From: Amanda Scholes on behalf of Planning.Responses
Sent: 16 October 2019 08:29
To: Planning Scanning
Subject: FW: Planning Consultation on: Y/63/19/RES

Comment from Greenspace

APPLICATION NO: Y/63/19/RES

Site Address: Bonhams Field Main Road Yapton BN18 0DX

Figure 3 – Open Space Landscape Strategy: Terra Firma 2019 (with annotations)

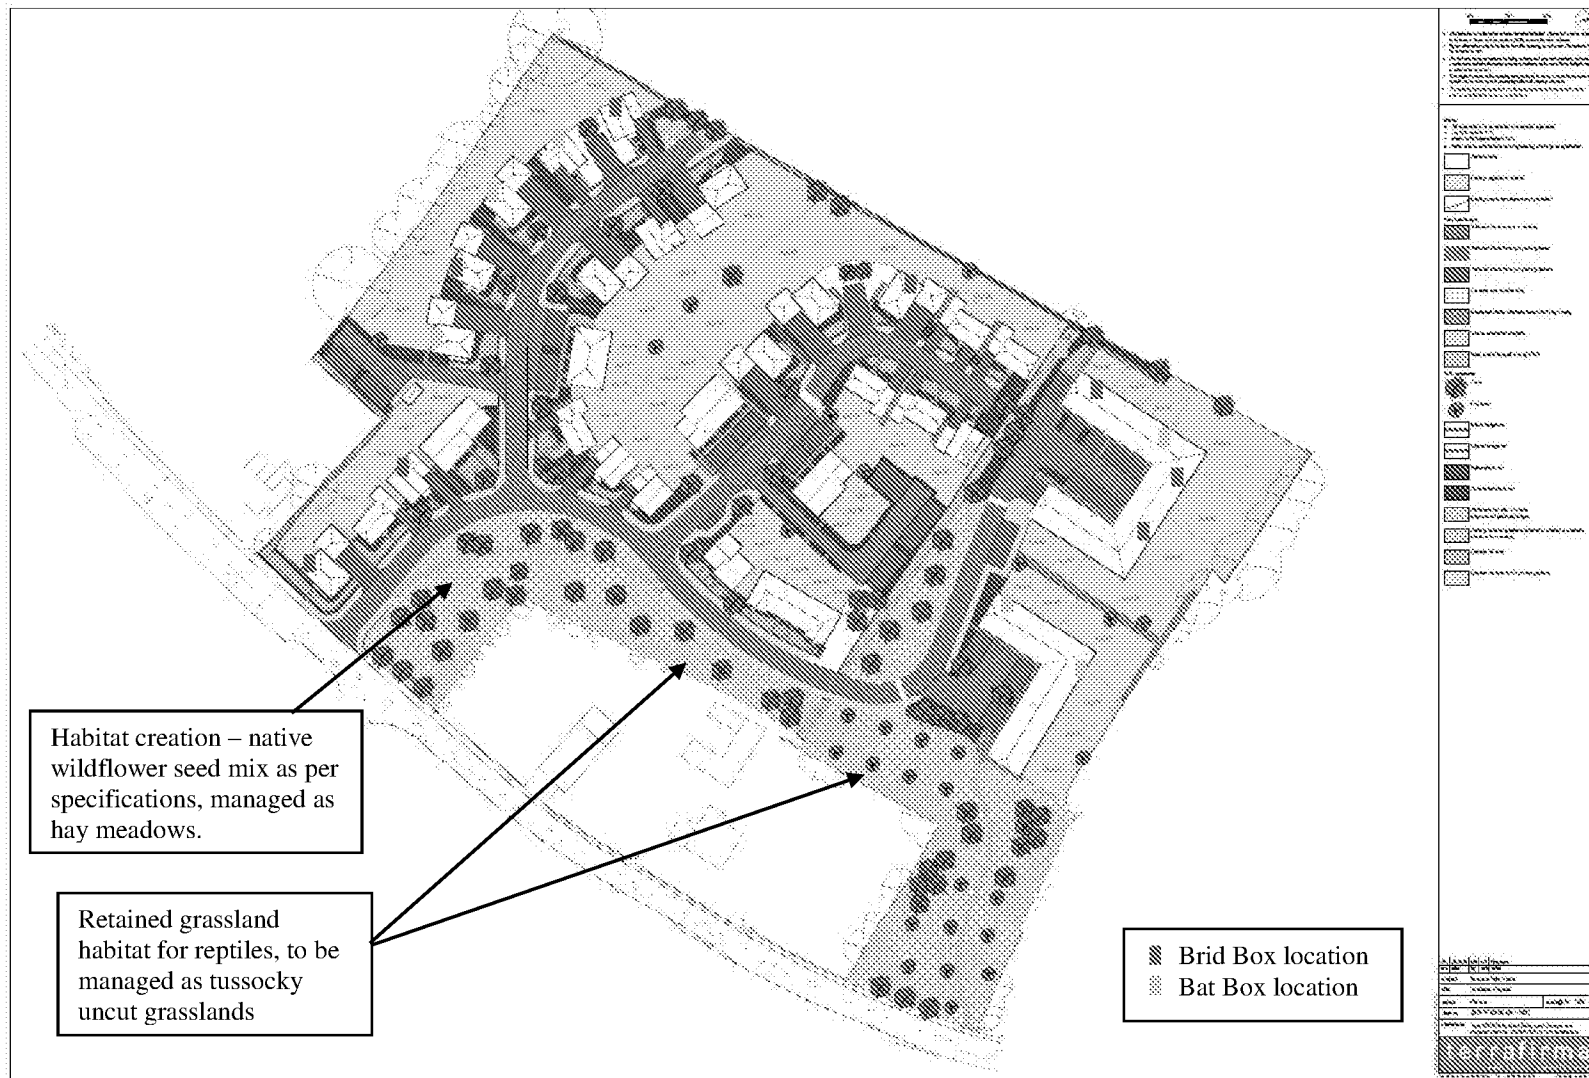
Indicative landscaping was shown in the landscape Strategy Plan submitted under outline planning application Y/1/17/OUT which clearly showed a green corridor to the east of the proposals which would have formed and allowed for the protection of valuable wildlife habitat. This green corridor indication would also serve to allow space for the offsite trees to the east of the proposals affording them space and protection to grow. This green buffer also indicated a landscape scheme which included 'proposed large native tree planting along the boundaries and within the open spaces to supplement the existing vegetation and to increase biodiversity' This would also have allowed for mitigation tree planting to provide some screening to the existing dwellings to the east.

A superseded plan under the same application did indicate some rear garden segregation, but still allowed for this buffer to remain, this would now not appear to be the case in this reserved matters application. I would have to **recommend an objection to the omission of this eastern green corridor from this reserved matters application.** Whilst I see a general improvement in the allowance of a good section of POS to the south of the development along with inclusion of the footpath through this area, I feel that the loss of the public open space now shown to the east of the development is detrimental to the scheme and mitigation provision tree planting to this area as previously shown and approved will now not be possible.

Indicative planting has been included in substitute plans Planting plan 2076-TF-00-00-DR-L-3001 and Landscape General Arrangement plan 2076-TF-00-00-DR-L-101. Whilst some detail has been provided there are significant gaps in the detail provided where this reserved matters application should be for the submission of a full landscape scheme to be submitted for approval, detailing species choice, position, densities and size at time of planting. This is required in plan and list form and in relation to the trees and vegetation to be retained so that a clear picture of the proposals can be seen. These details are required to ensure that appropriate screening is provided, maintaining and uncompromising the setting and ensuring that the proposals fit within the area of neighbouring development. We note that the information contained within these drawings is insufficient in the detail above and whilst provides a scheme which is fitting for location in species choice further detailing particularly regarding quantities and densities still needs to be provided.

There is mention in the above drawings of unequipped Play area scheme, which needs to be elaborated upon regarding location and detail of what is to be included. Whilst a LAP is generally unequipped it is for the purpose of natural play and should therefore contain natural elements such as mounds, logs, boulders and would be expected to also include a seat and bin. Please ask for confirmation of the detail for this.
